Our Ref: R/2018/25/A
File No: 2019/613710

SSD 9571 – UTS Blackfriars Precinct Research Building Stage 2

Thank you for your correspondence dated 7 November 2019 requesting for the City of Sydney Council (“the City”) to comment on the State Significant Development (SSD) Stage 2 detailed proposal for the UTS Blackfriars Precinct Research Building.

Figure 7. "Rain Falls" – Diagram of Option 1 from the Artwork Report

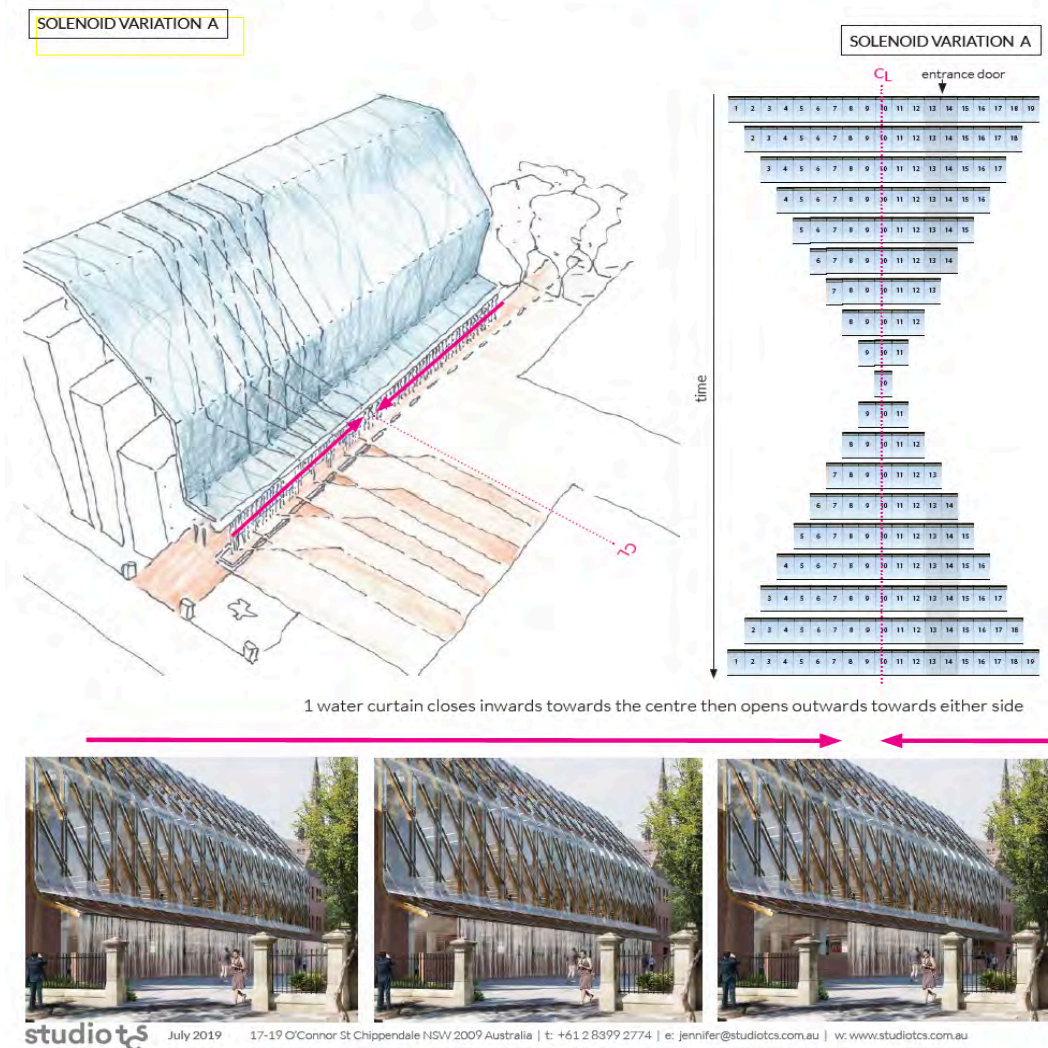
The Public Art Report for the 'Rain Falls' water art work, prepared by Studio TCS, provides two options for the sequencing water flow of the art work. The City recommends that 'Option 1 – Multiple sequences with solenoids' be pursued given the reasonable cost and the scale of the development.
